**Property
NSW**

RE: REDEVELOPMENT OF COCKLE BAY WHARF, DARLING HARBOUR (SSD7684)

Derived Envelope

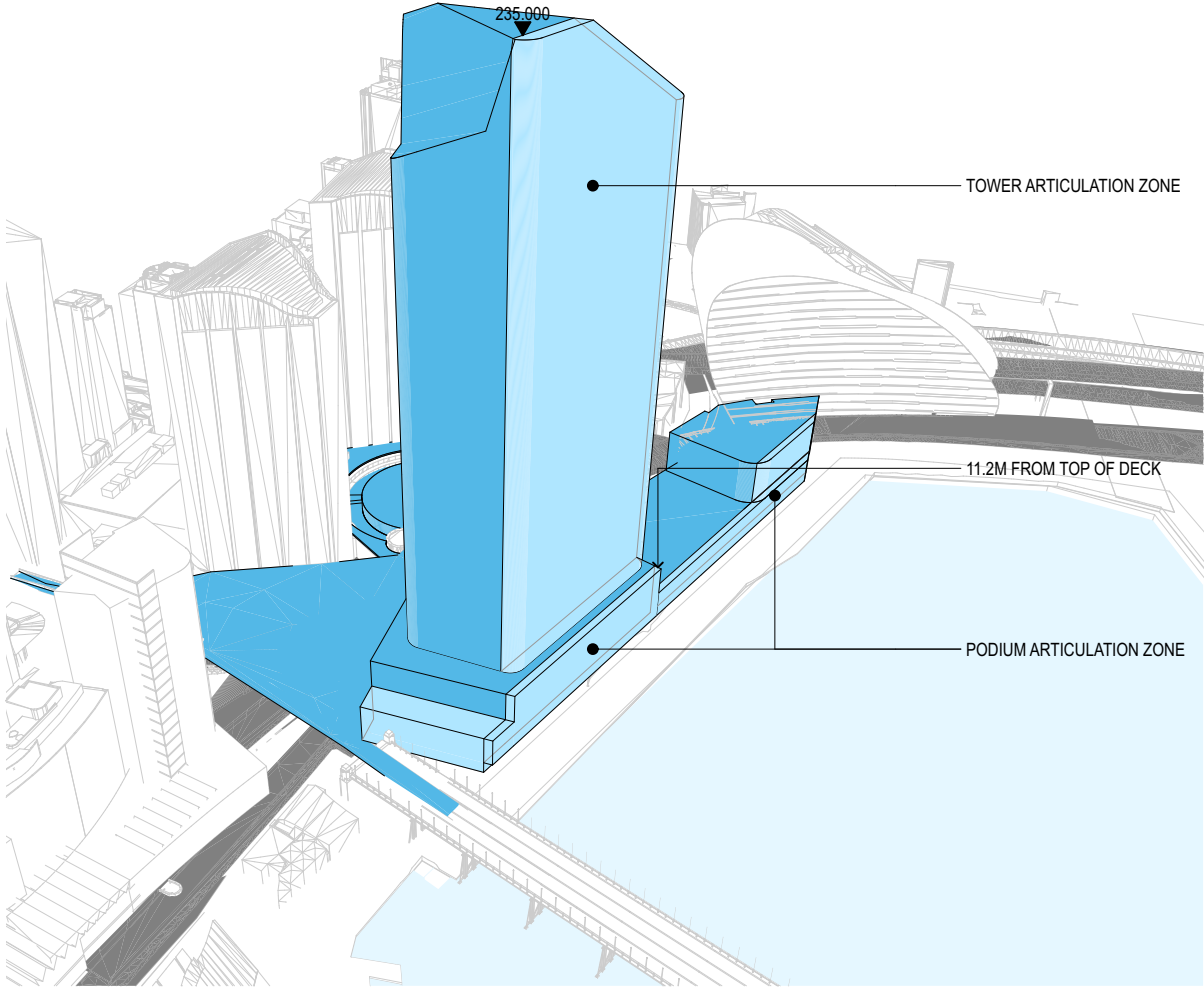
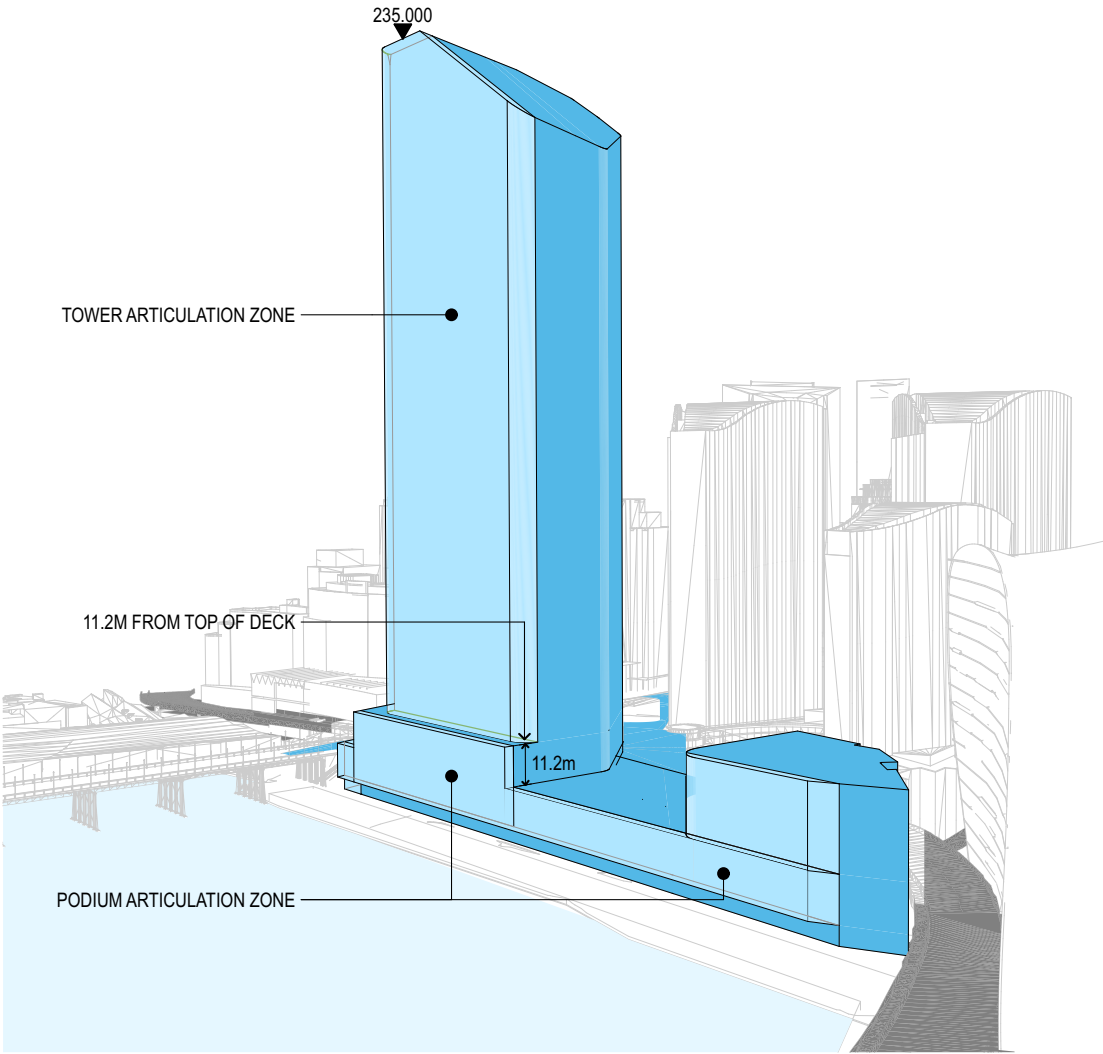
- a. The excessive height (235m) and proposed floorplate (2,700sqm) of the proposed commercial tower in the setting of Cockle Bay and the introduction of an unsatisfactory bulk and scale into Darling Harbour;
- b. The proposed public domain benefits such as the proposed pedestrian linkages, new park, open space, connectivity between the CBD and Darling Harbour to ensure they are sufficiently unique and beneficial to the public to justify the proposed scale of development; and
- c. How the bulk and scale of the proposal along the foreshore contributes to an open and spacious Cockle Bay.
